Side two storey extension, front dormer, front porch and new detached garage
2 Elm Avenue East Preston

Thank you for your internet representation made on 12th October 2012 which has been recorded as **an objection** with the comments as follows:

I am commenting on this application on behalf of the East Preston and Kingston Preservation Society. ☐

SITE PLAN 1:500 SCALE.
08/09/2012

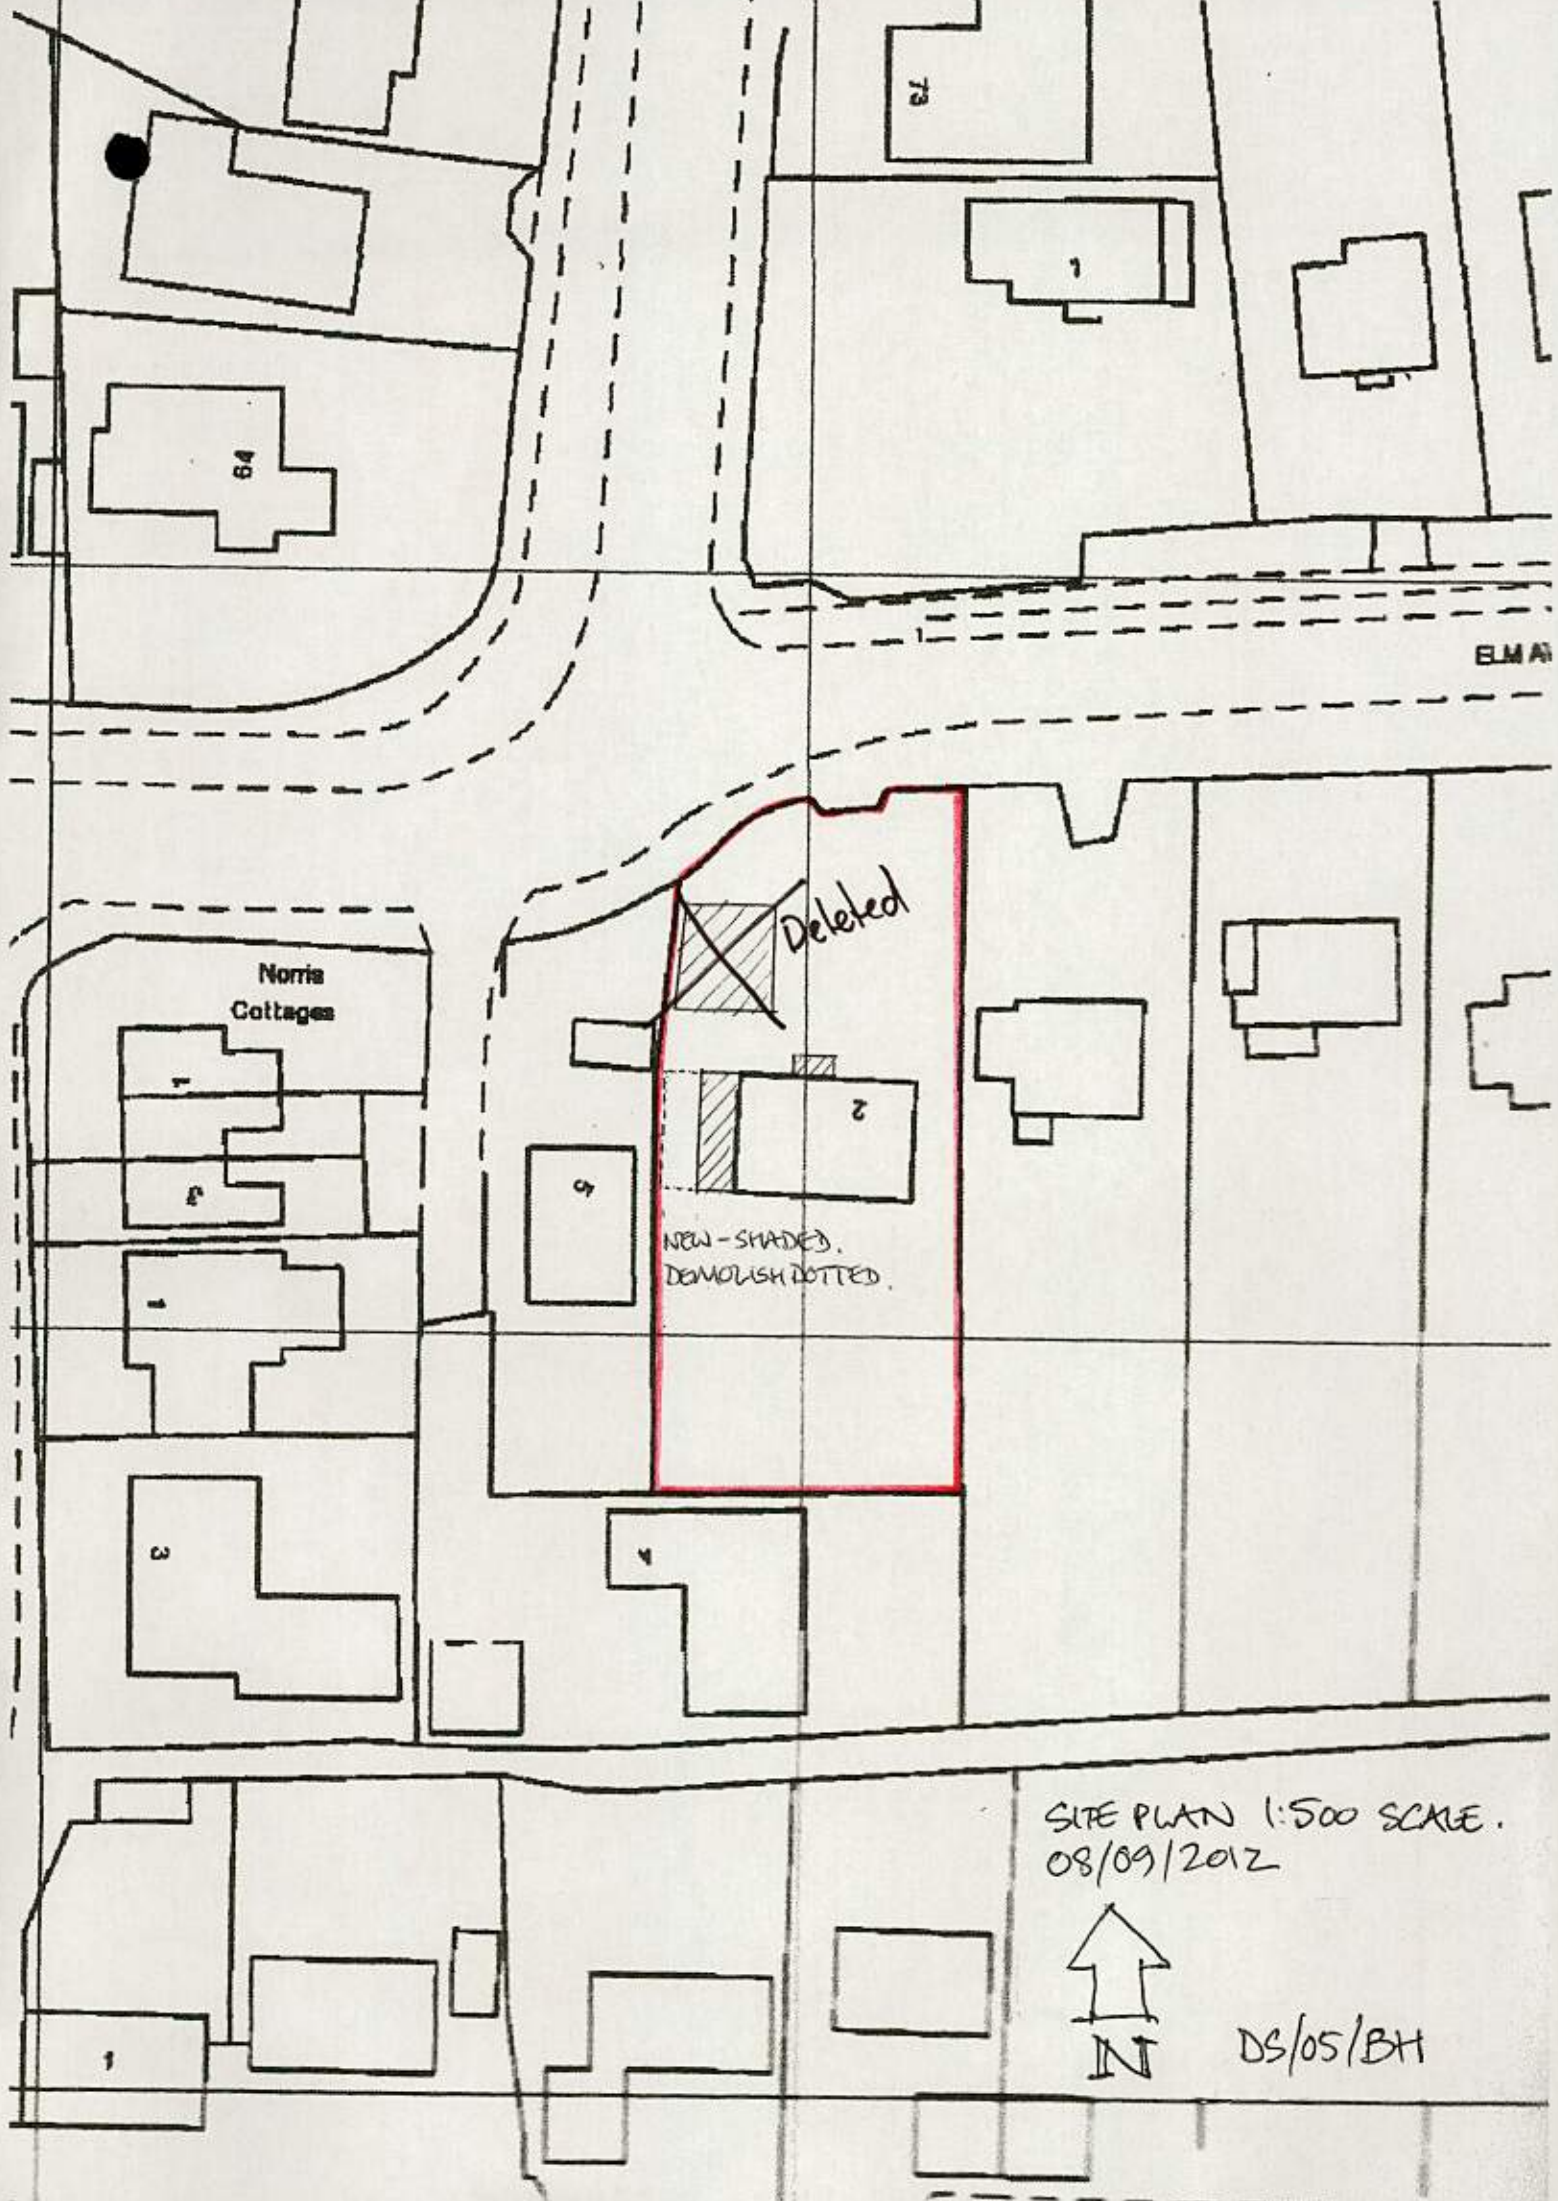
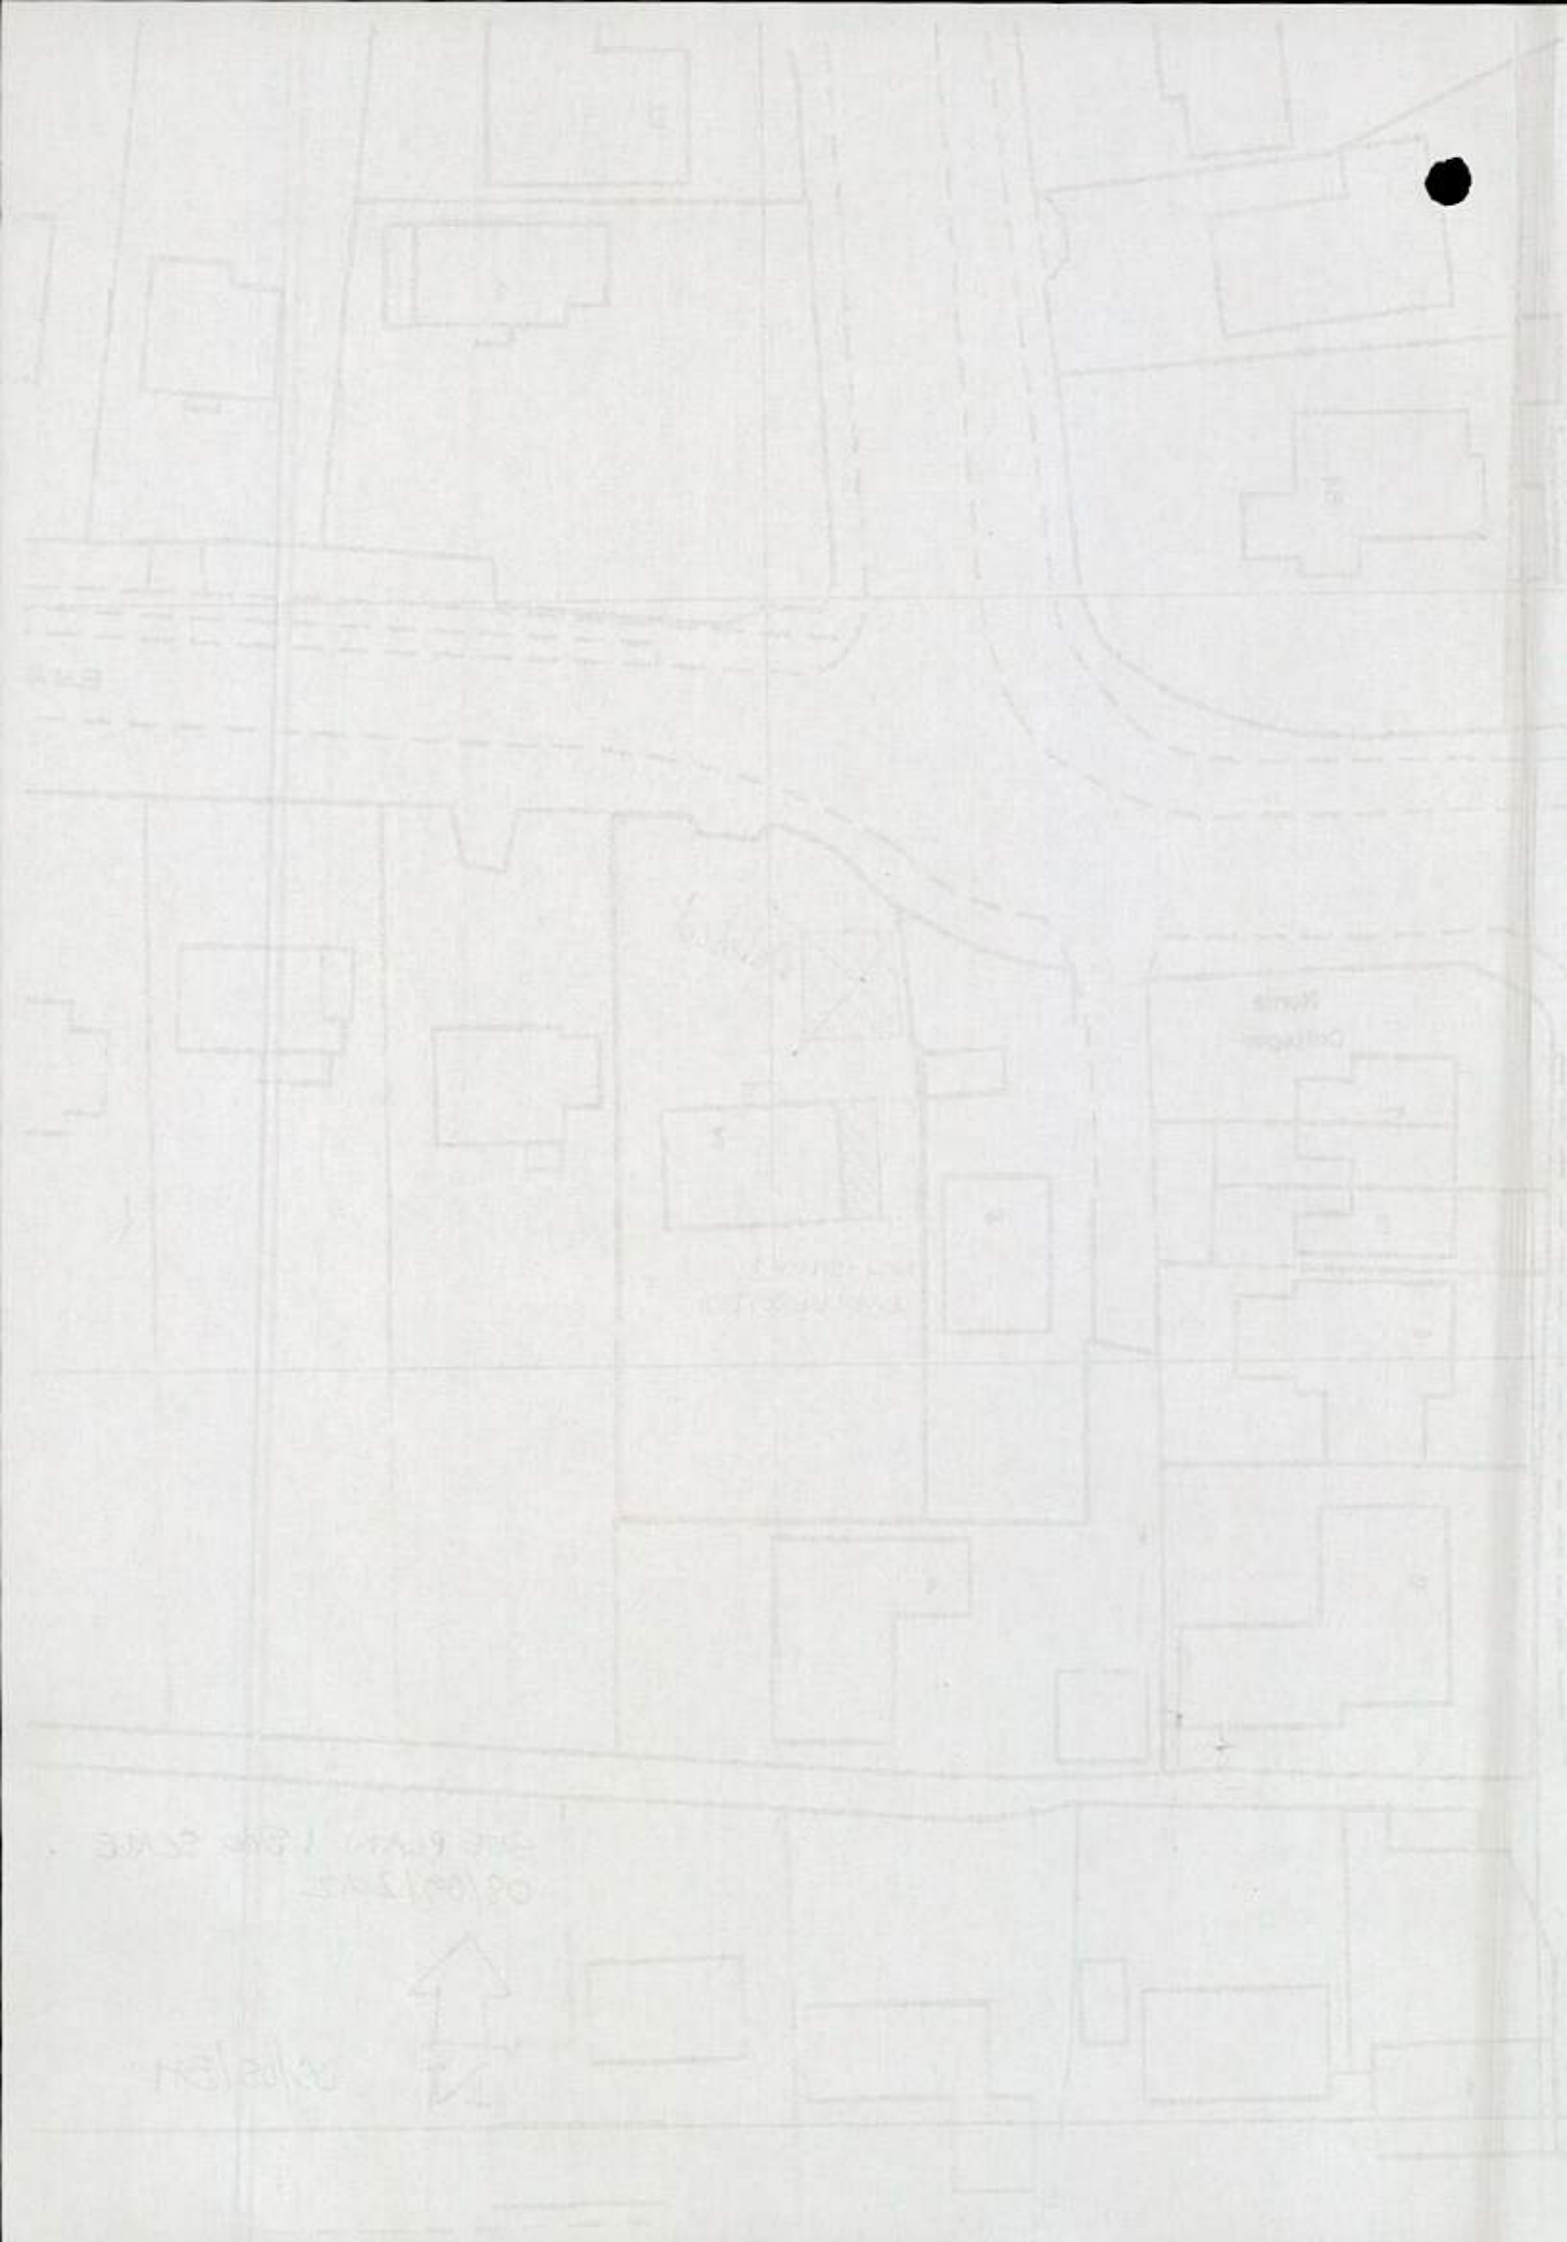
1. The position of the new garage, close to the road and ahead of any existing buildings in the road, would conflict with policy GEN7, because it does not respond positively to the characteristics of the site; with policy DEV19, because it affects the spatial character and pattern of the street; and with the guidance concerning the Elm Avenue Area of Special Character, which emphasises the importance of the regular building line in the area. ☐

For these reasons, this application should be refused. It might be acceptable if the garage was omitted, and if the materials used on the house were brick and rendering to match the materials in adjoining houses. ☐
